CITY OF ALBUQUERQUE

July 22, 2019

Re: Solare Collegiate Charter School
8801 Gibson Blvd. SW 87121
Traffic Circulation Layout
Engineer's/Architect's Stamp 06-07-2019 (M09D031)

PHASE CDS

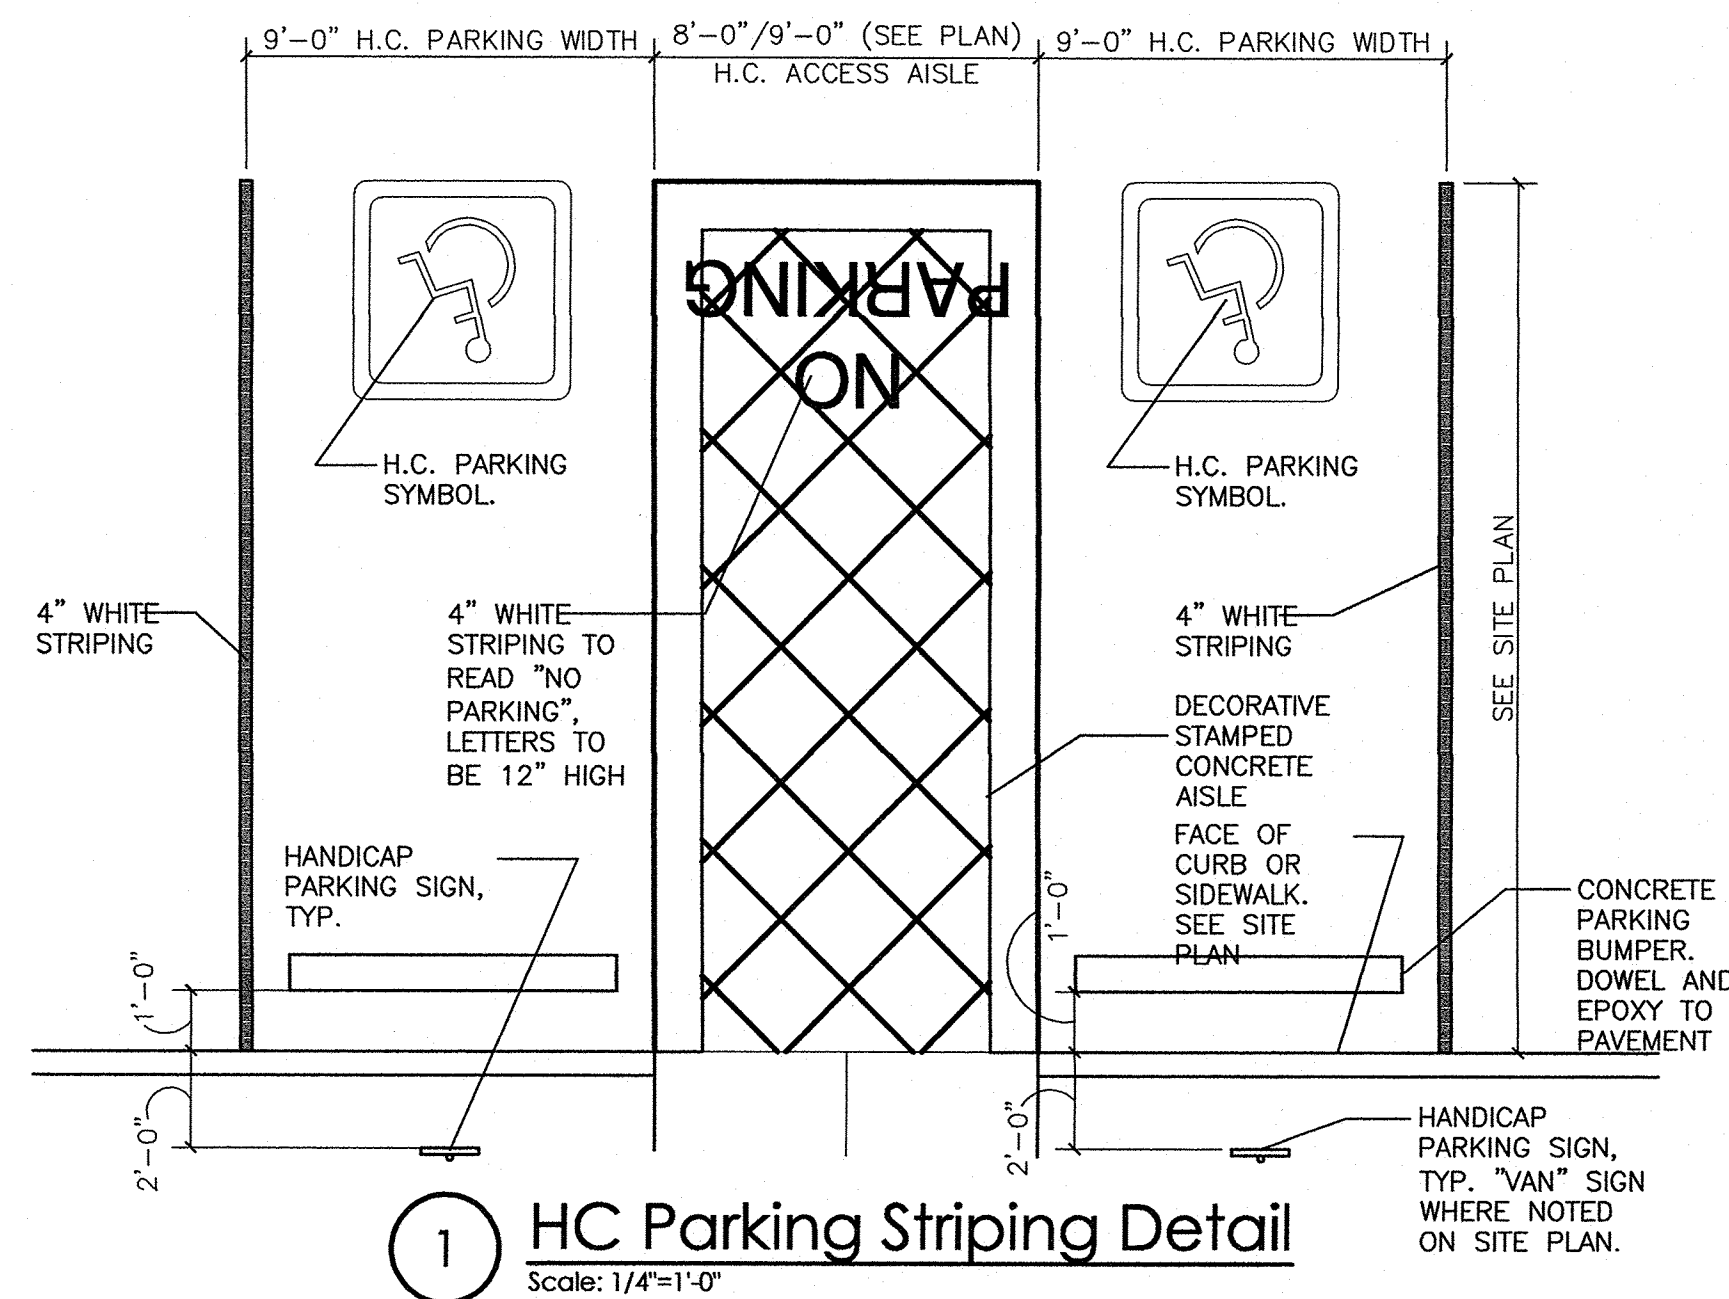
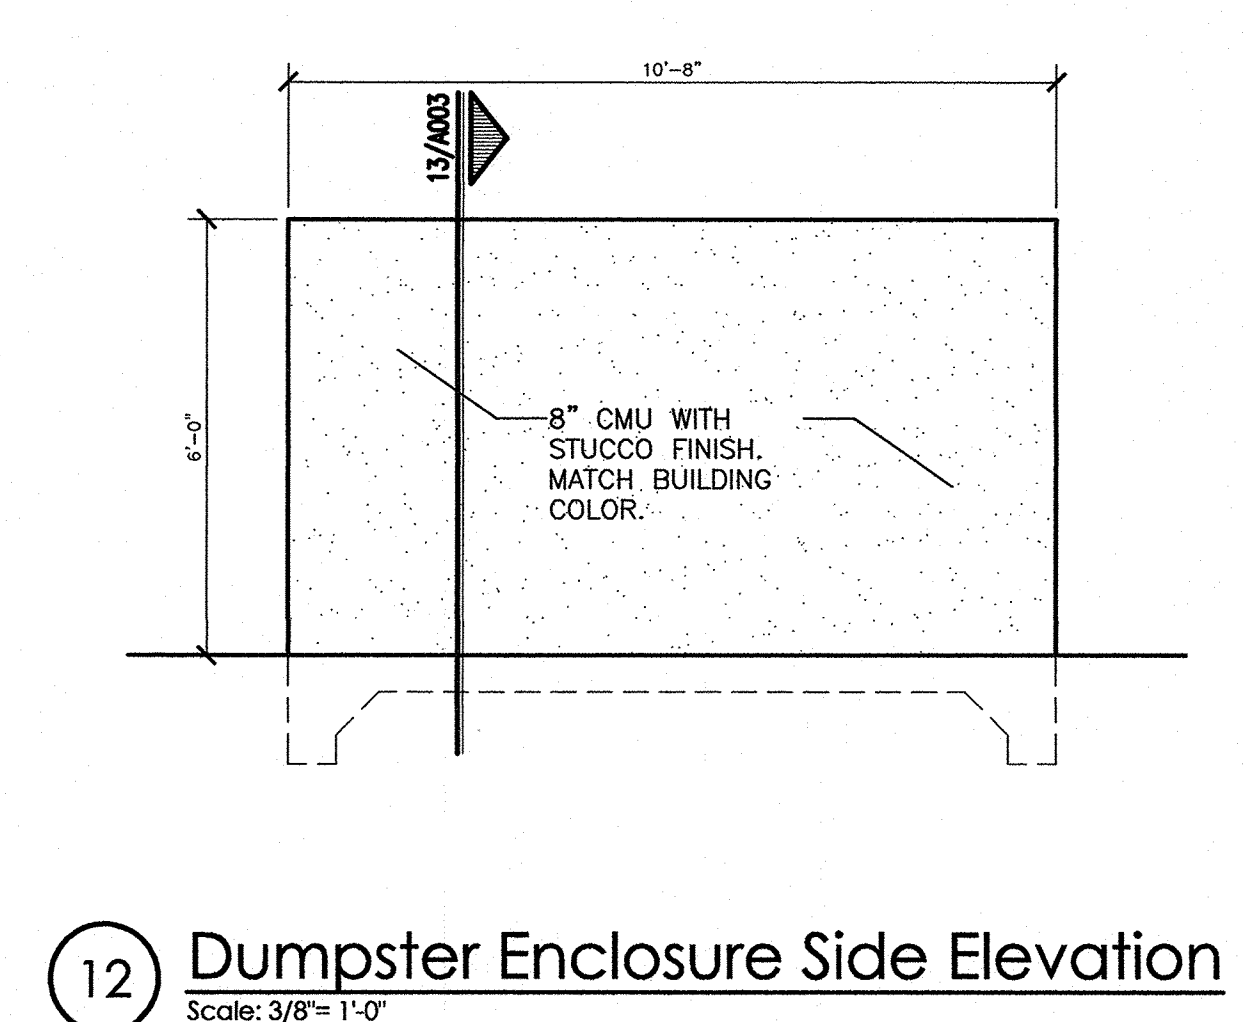
1. One-way vehicular paths require pavement directional signage and a posted "**Do Not Enter**" sign at the point of egress. Please show detail and location of posted signs.

2. Show the clear sight triangle and add the following note to the plan: "Landscaping and signage will not interfere with clear sight requirements. Therefore, signs, walls, trees, and shrubbery between 3 and 8 feet tall (as measured from the gutter pan) will not be acceptable in the clear sight triangle."

3. Please line up your access on Barbados Ave. SW with ranchers Rd. SW.
4. Provide notes showing what work is included and on the work order and the private work on site.

5. Work within the public right of way requires a work order with DRC approved plans.
6. Please add a note on the plan stating, "All improvements located in the Right of Way must be included on the work order."

7. Please match the infrastructure list with what is shown on TCL. The sidewalk on Barbados Ave SW is not shown in the infrastructure list.
